Recommendation Report for Lawful Development Certificate for a Proposed Use or Development

REF NO: **A/269/21/CLP**

LOCATION: 5 Ham Manor Farm Cottages
West Drive
Angmering
BN16 4JF

PROPOSAL: Lawful development certificate for a proposed front porch extension and rear single storey extension and alterations

Brian Heap Architectural Consultant		5 Ham Manor Farm Cottages West Drive Angmering BN16 4JF	
Tel: 01905 830000 brianheaparchitect@btconnect.com		Floor Plans as Proposed	
		December 2021	1:50 at A3
		Drawing No. 21-20114-06B

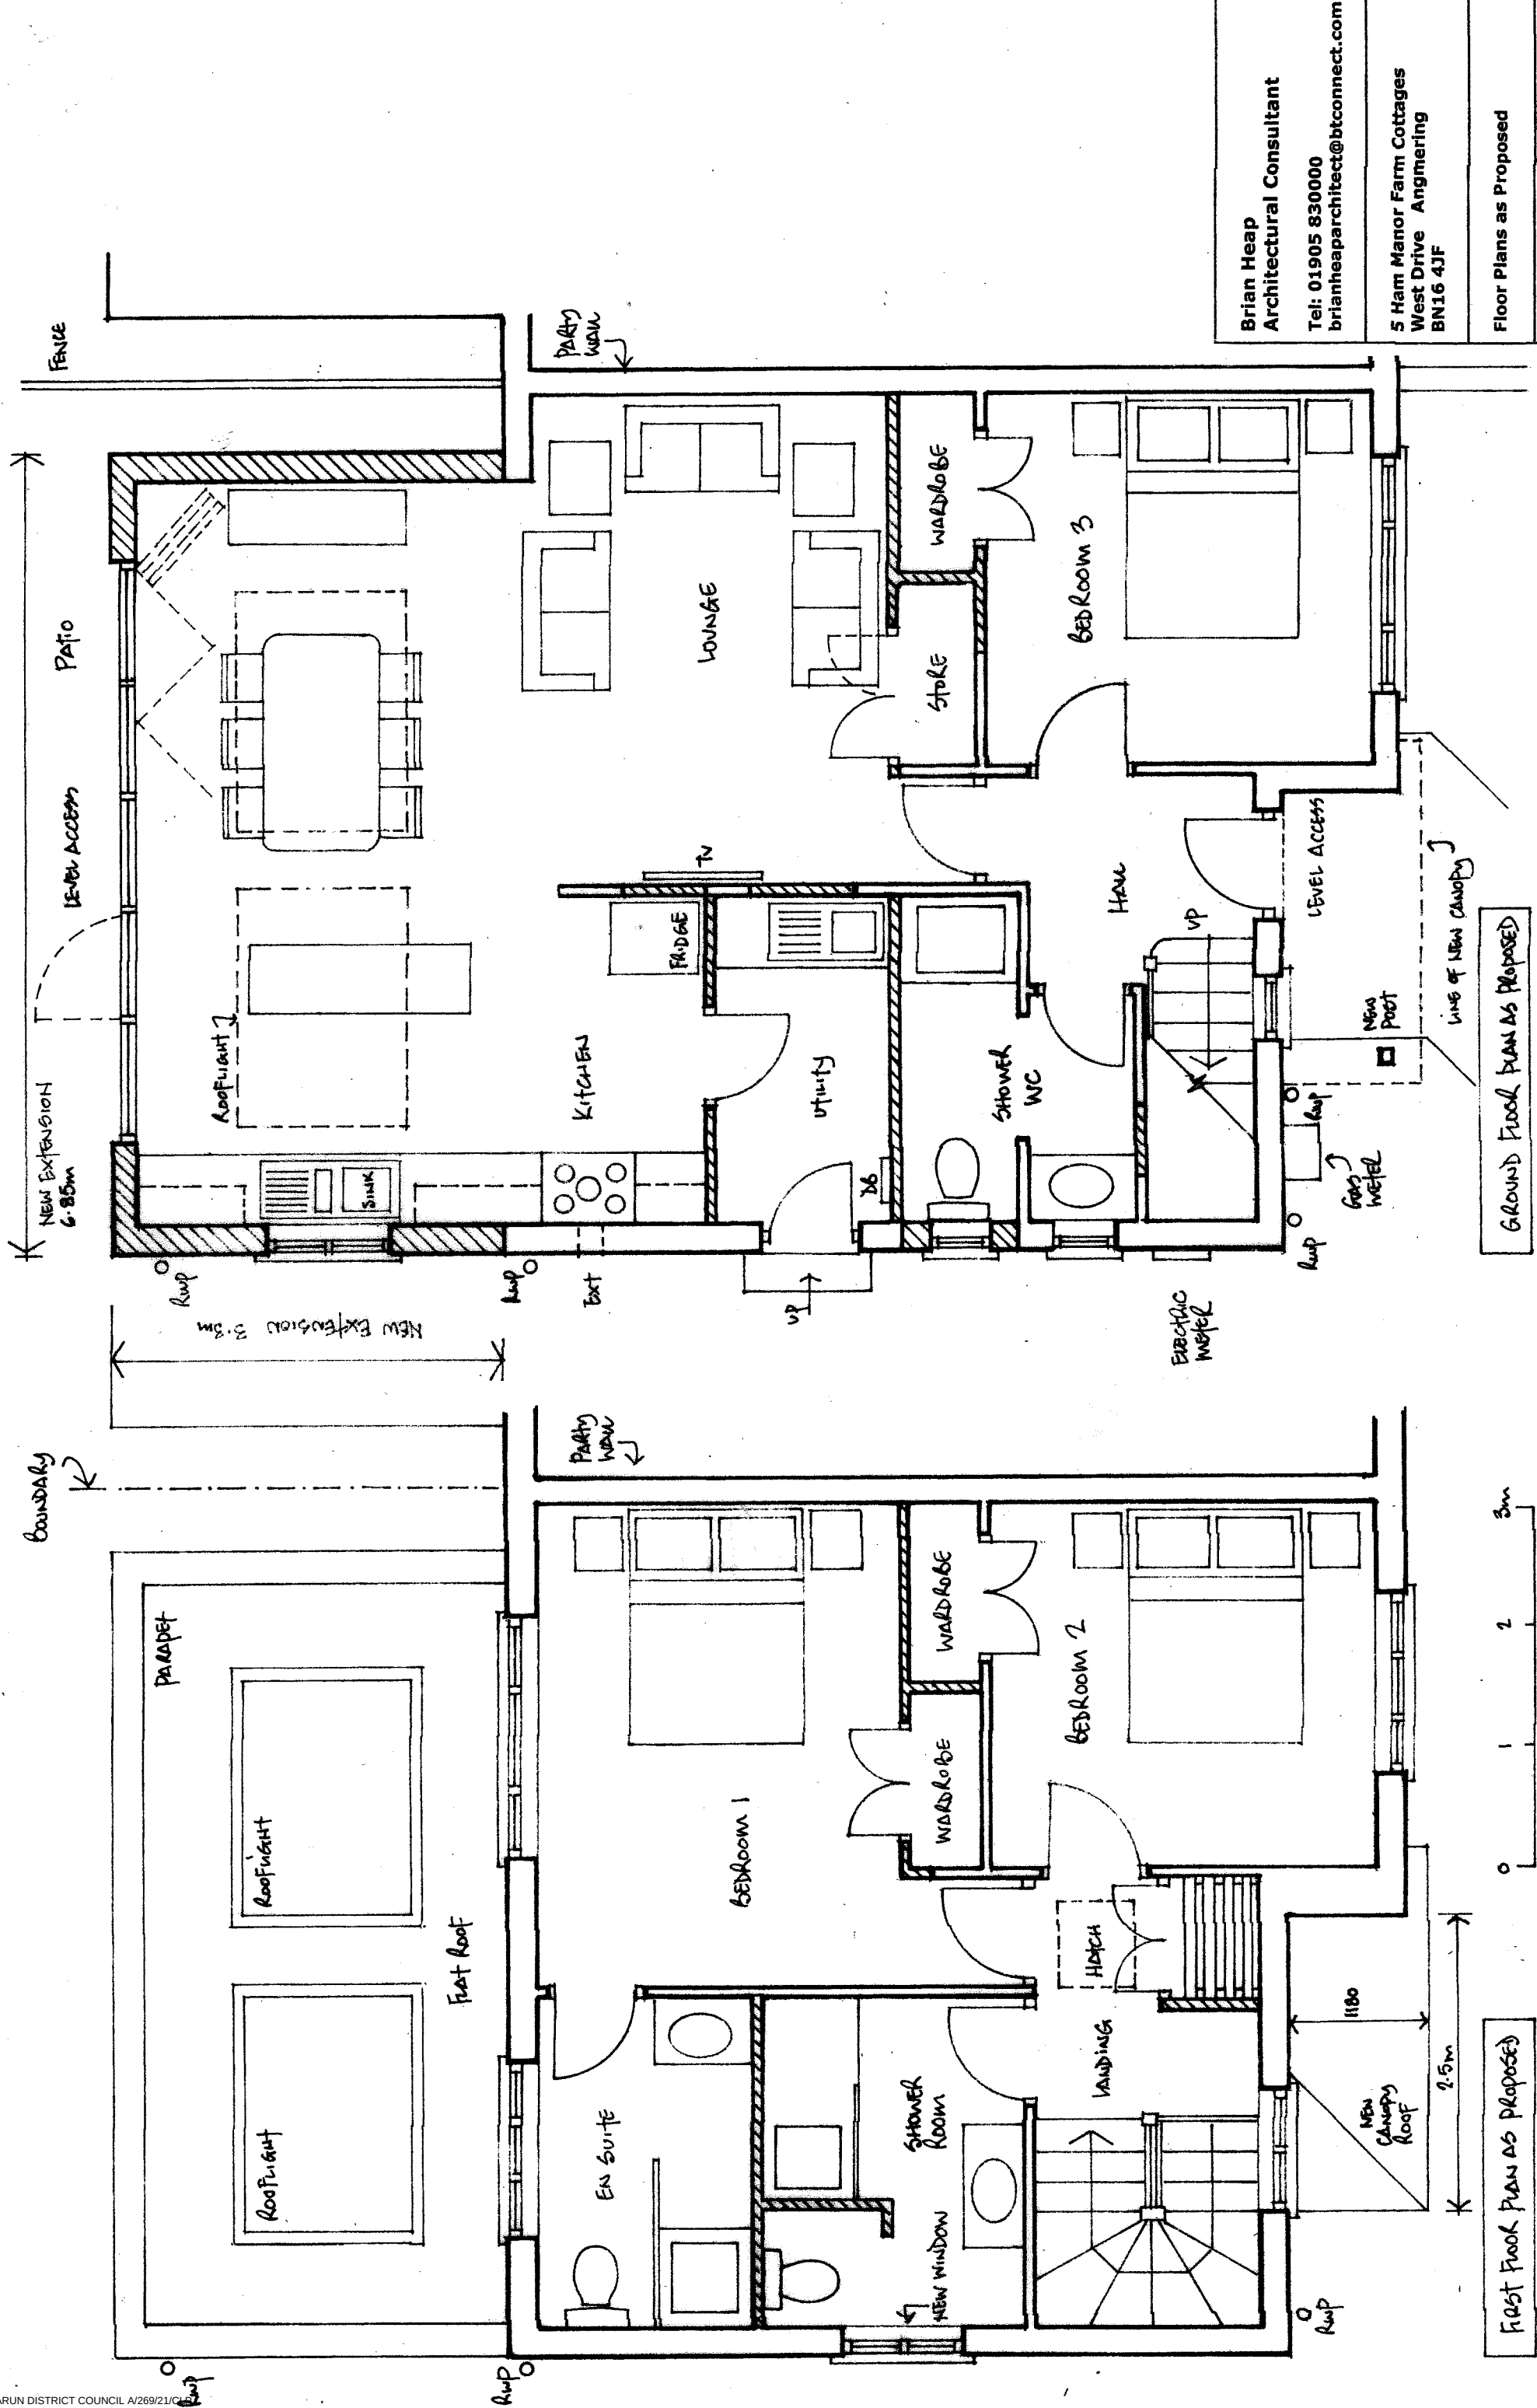
The proposed single storey rear extension and front porch do not comply with relevant sections A.1(fi) and D.1(c), in that the rear extension is over 3m in depth and the porch is over 3m in height. It is therefore, not considered permitted development and as such, requires the submission of an application for full planning permission.
